From: Nicola Swann [REDACTED]
Sent: 12 September 2019 13:42
To: Planning.Responses <Planning.Responses@arun.gov.uk>
Subject: Pagham responses

Pagham Parish Council have considered the following applications at a meeting of the Planning Committee held on 10th September 2019:

PROPOSED BOUNDARY FENCE AT 42, THE CAUSEWAY, PAGHAM FOR MR. R. BUTTERS.

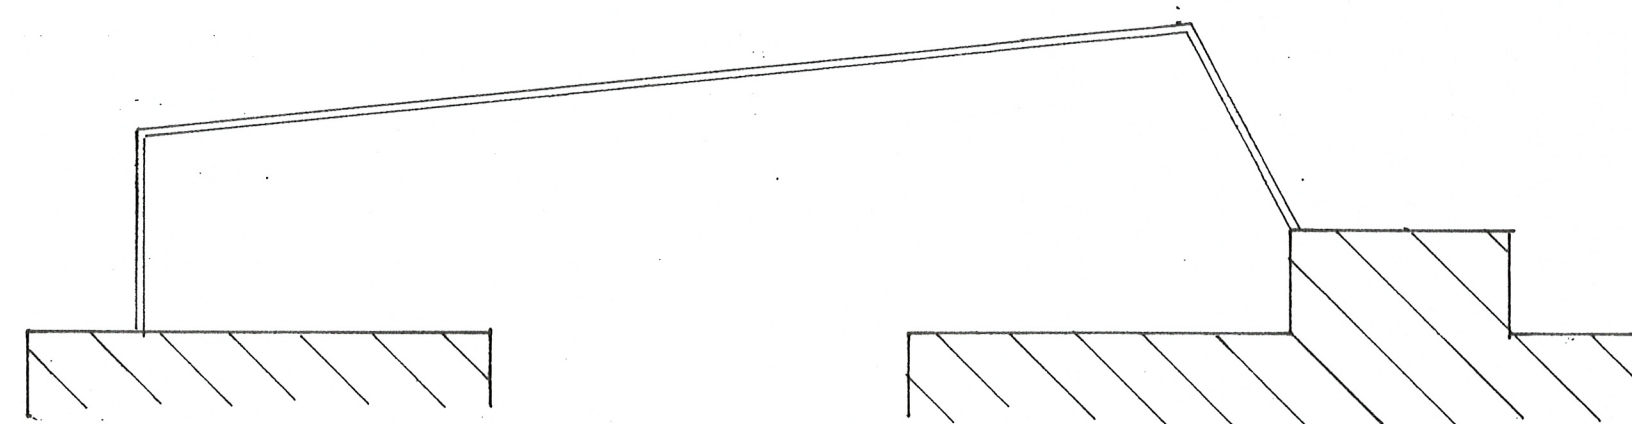
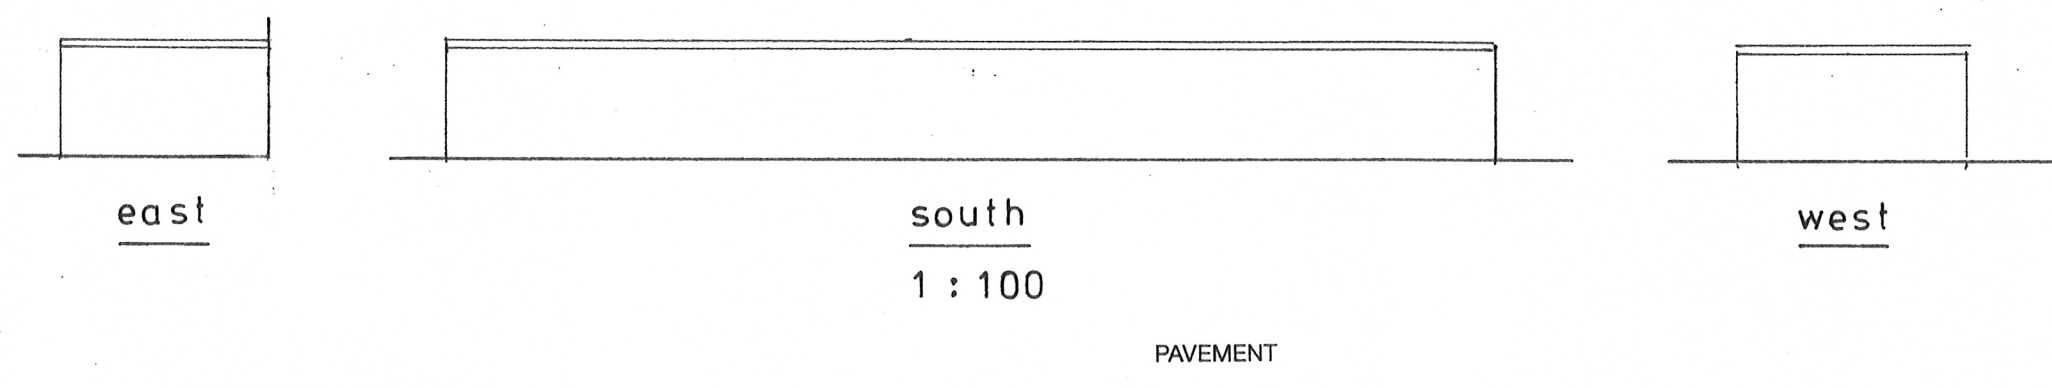
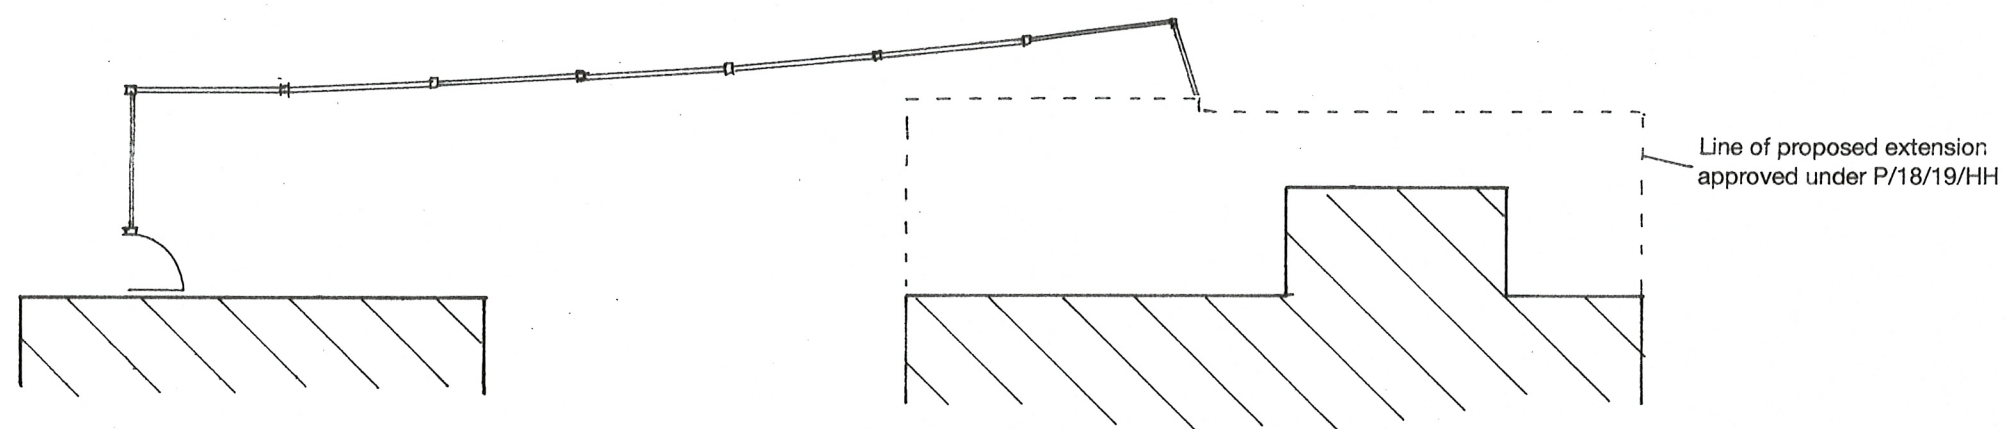
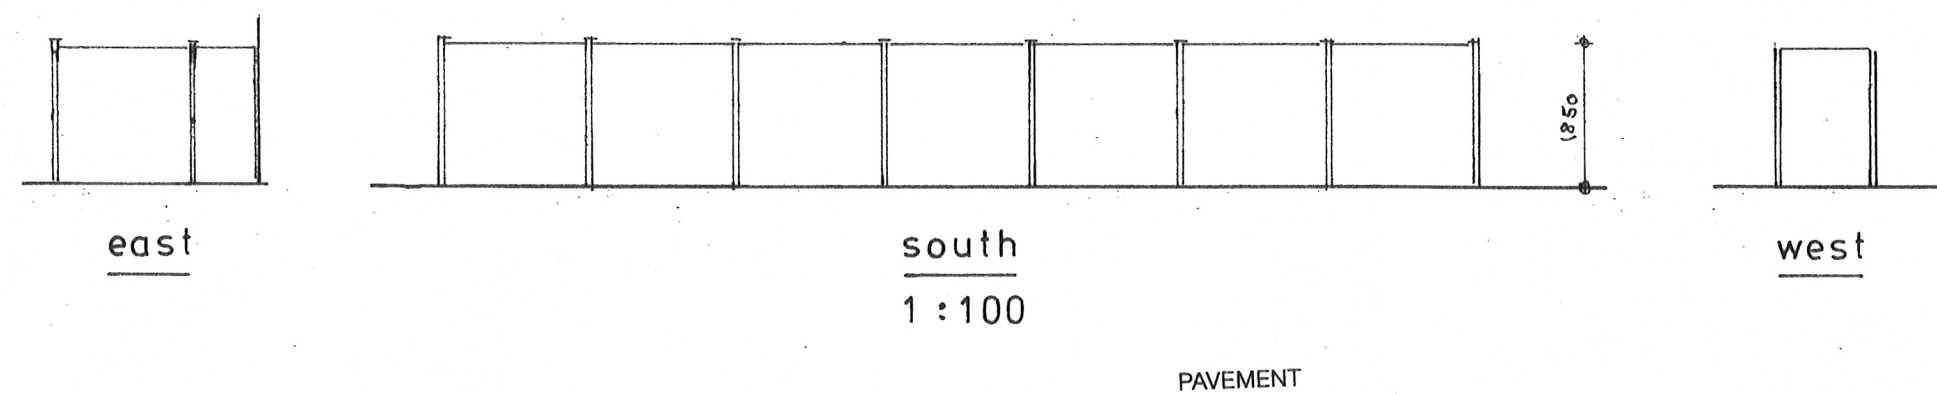
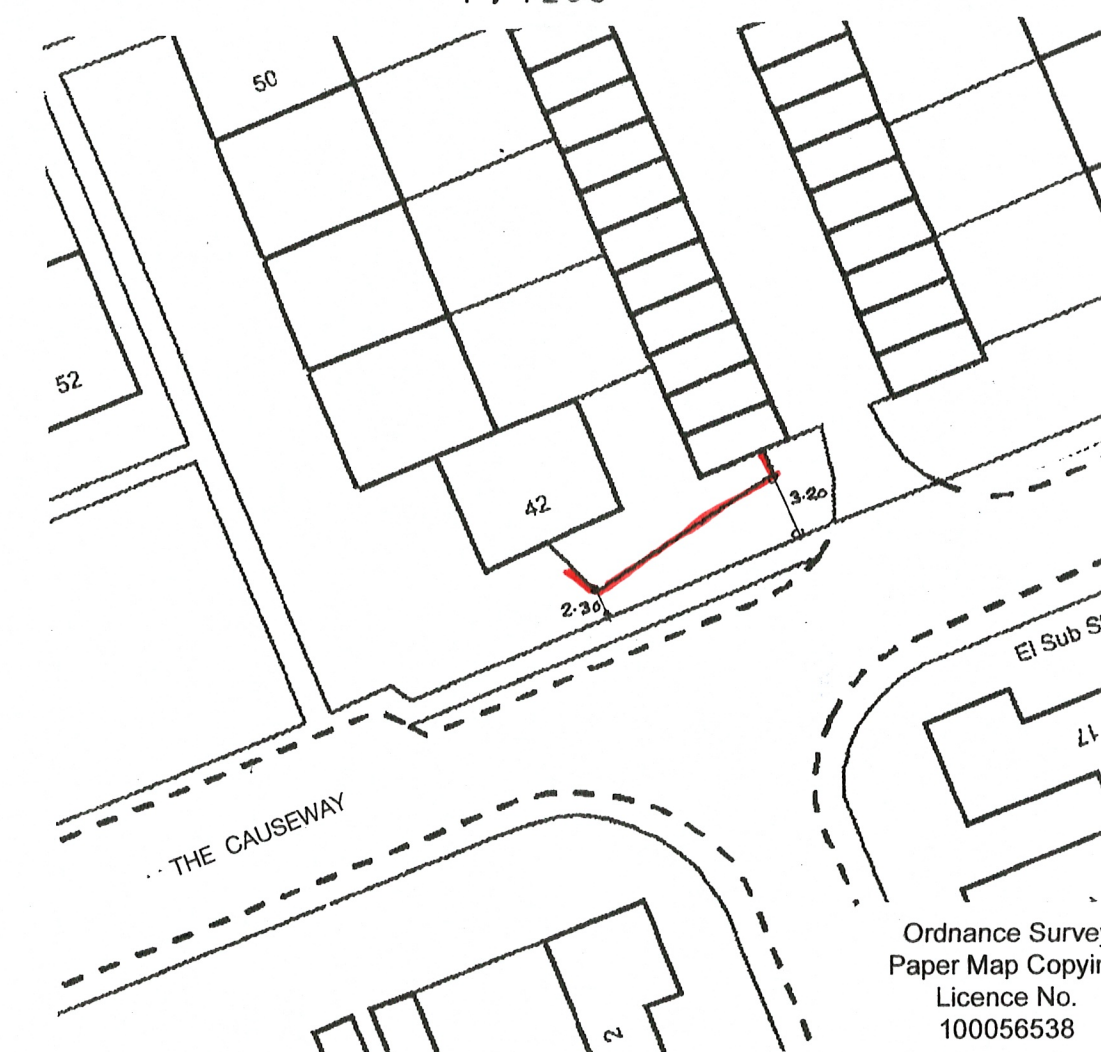
- 6.6** P/69/19/OUT – 42 The Causeway Pagham PO21 4PG – Removal of boundary wall and erection of boundary fence at front of property **RESOLVED: NO OBJECTION but the Council would like to see more planting to screen the fence to soften the visual impact.**
